# CITY OF ALBUQUERQUE

PLANNING DEPARTMENT – Development Review Services

**RE: Affinity At Albuquerque Senior Housing - McMahon & Finland  
Drainage Plan for Site Development for Building Permit  
Engineer's Stamp Date 4-25-2014 (File: A11D014)**

- 3: \\20140292\CDP\Exhibits\Easement Vacation.dwg  
 Plotted, 16-Apr-2014 - 4:01:pm, Plotted by: MSATCHES

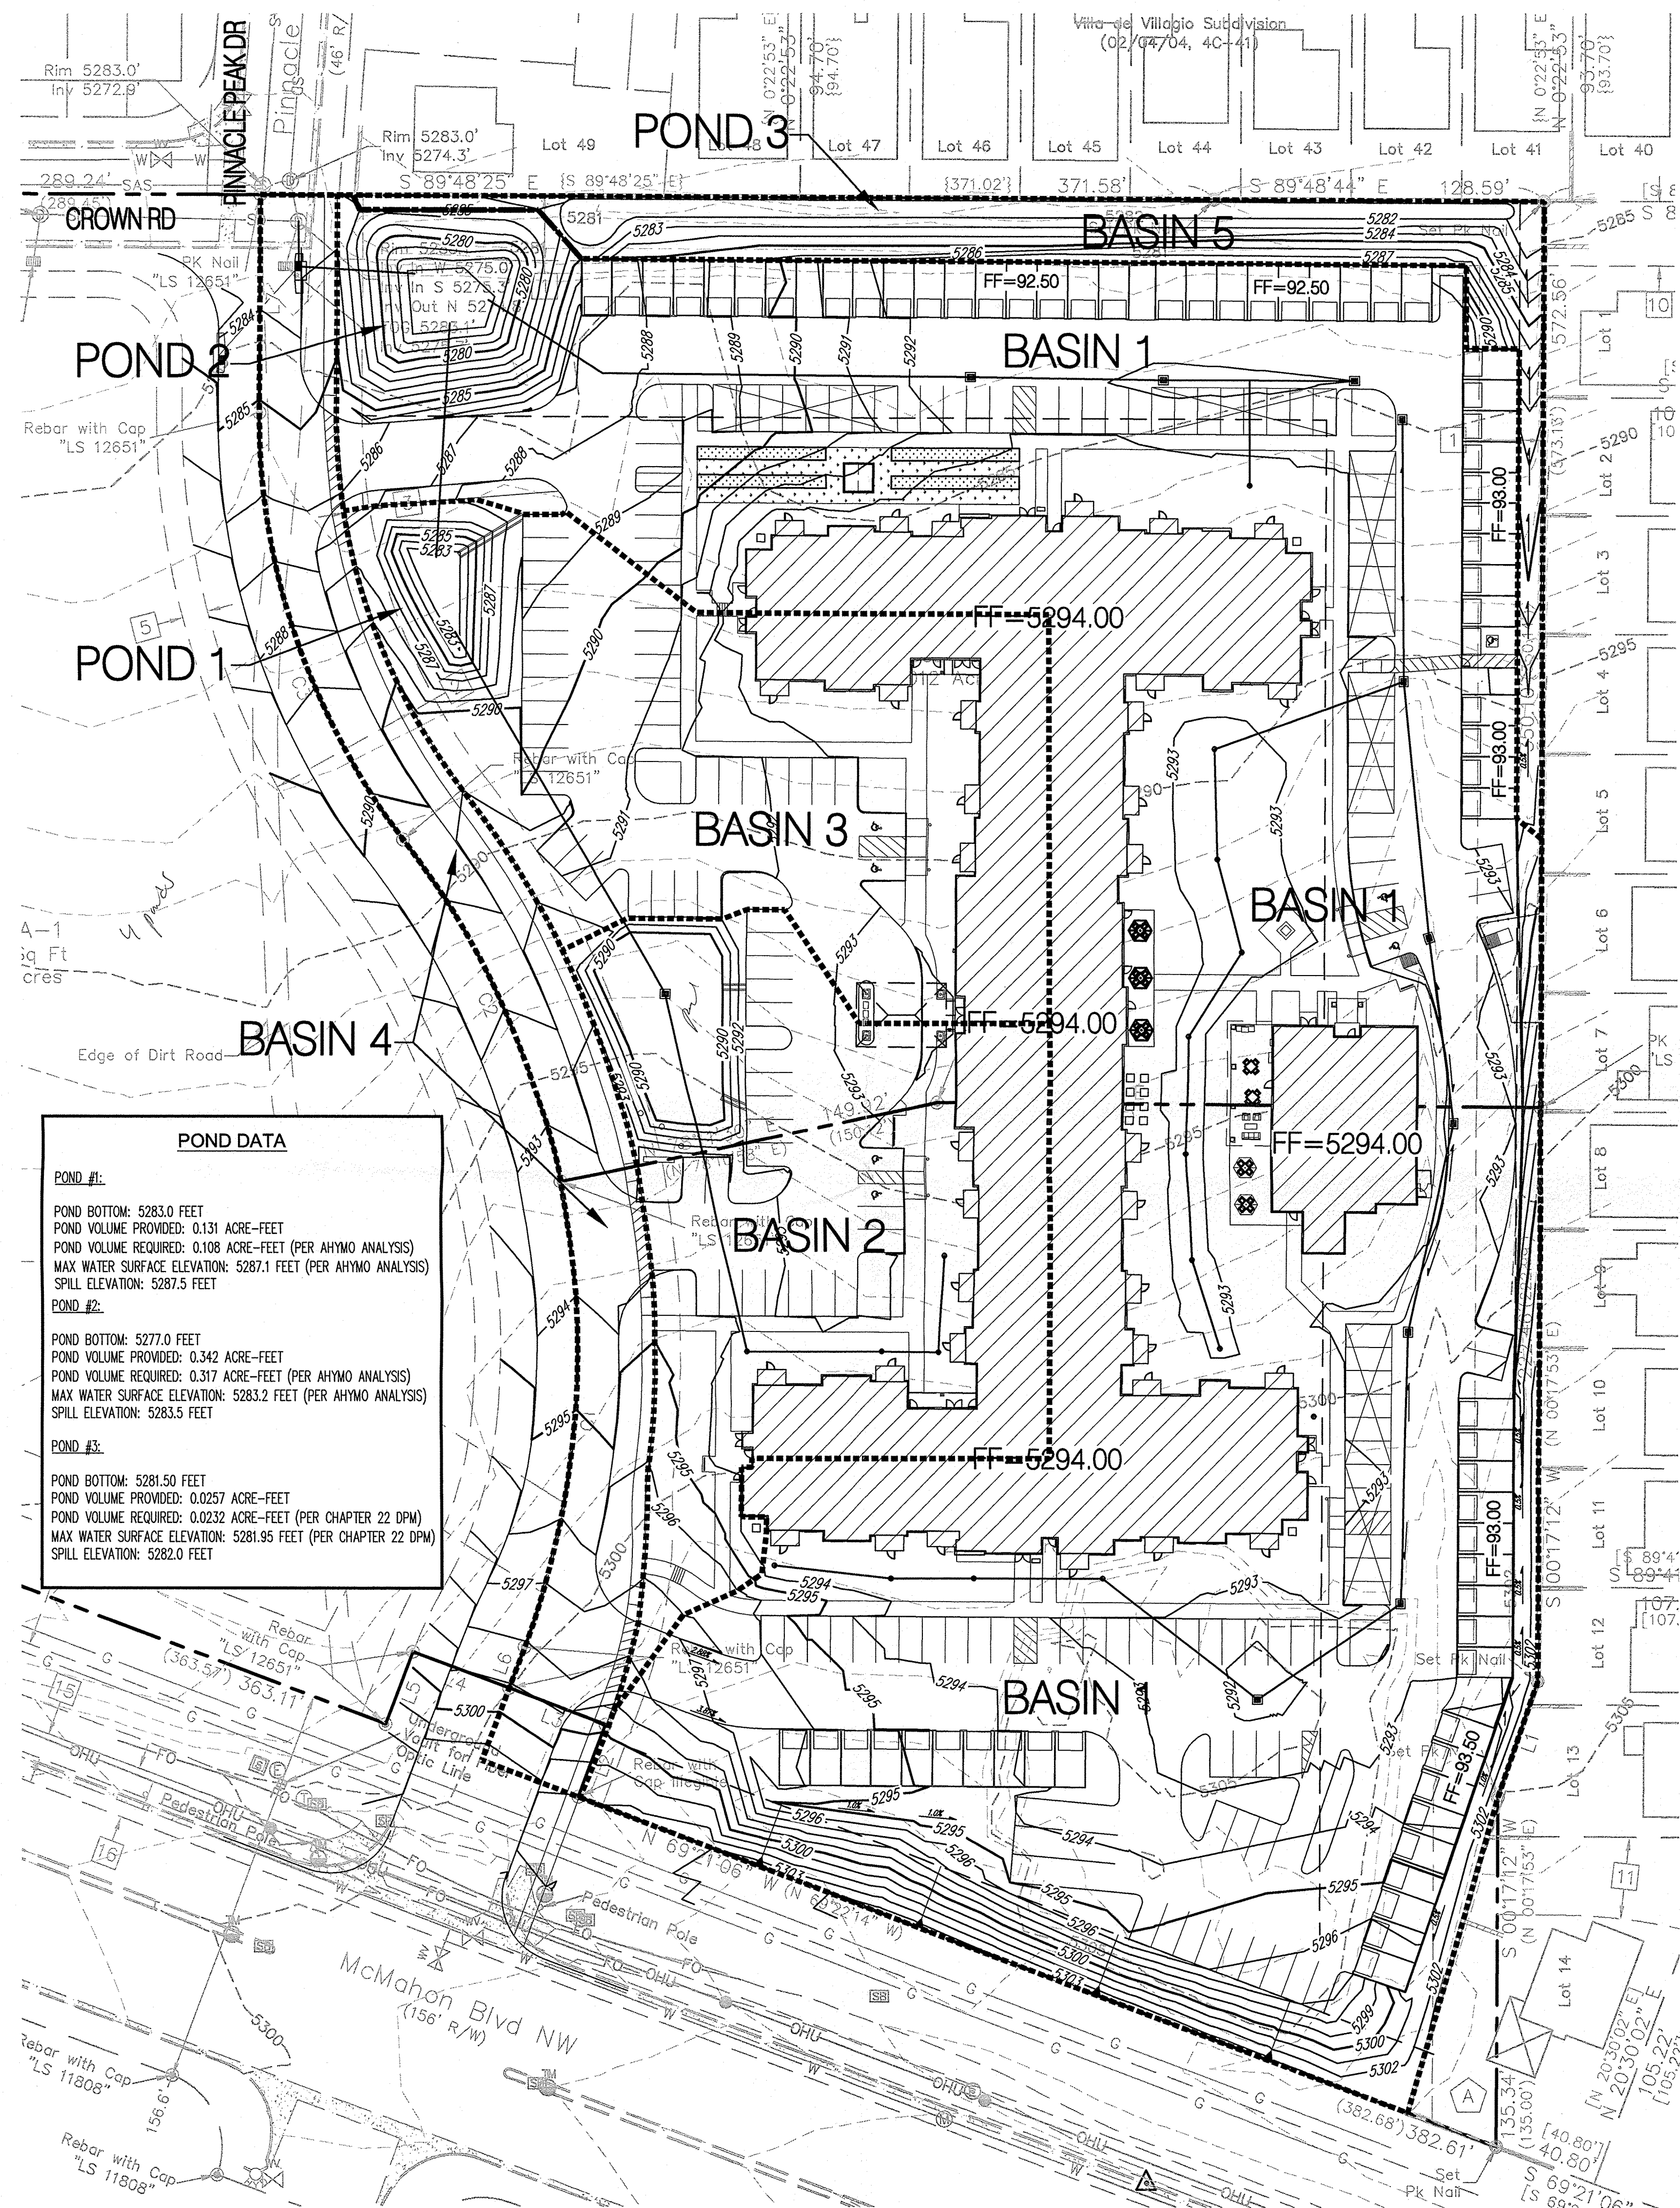
1. Plat indicates 25' pedestrian access easement on north and east boundaries. Water harvesting areas do not accommodate pedestrian access at the given slopes. Is the intent to vacate the easement? Is the intent to vacate the utility easements as well?
2. If the intent is to drain the carport to the parking lot, roof gutters should be shown on all cross-sections.
3. Pond #2 would overflow into Basin 5 as shown. Is the concrete wall intended to separate Pond #2 and Basin #5? Indicate the extents of the concrete retaining wall that is intended to prevent flow to property to the north.
4. Basin #5 along north side of property appears to act as a retention pond. Please provide pond volume calculations and WSEL. How is emergency overflow handled for this pond.

1. Included in this re-submittal is a copy of the vacation action exhibit showing the 25' pedestrian access easements to be vacated (DRB #1000875).
2. Carports will drain to the parking lot. Garages shown in the cross-sections on the grading plan will also drain to the parking lot. Roof gutters have been shown in the revised cross-sections.
3. The wall is intended to separate Pond #2 and Basin #5. The grading plan has been updated to better graphically represent the extent of the wall.
4. Basin #5 contains a shallow water harvesting area along the north portion of the property. Pond volume and water surface elevation calculations have been provided on the drainage management plan. The water harvesting area was sized to fully retain the 100 year 10 day storm. Calculations for the runoff volume are provided on the updated DMP.
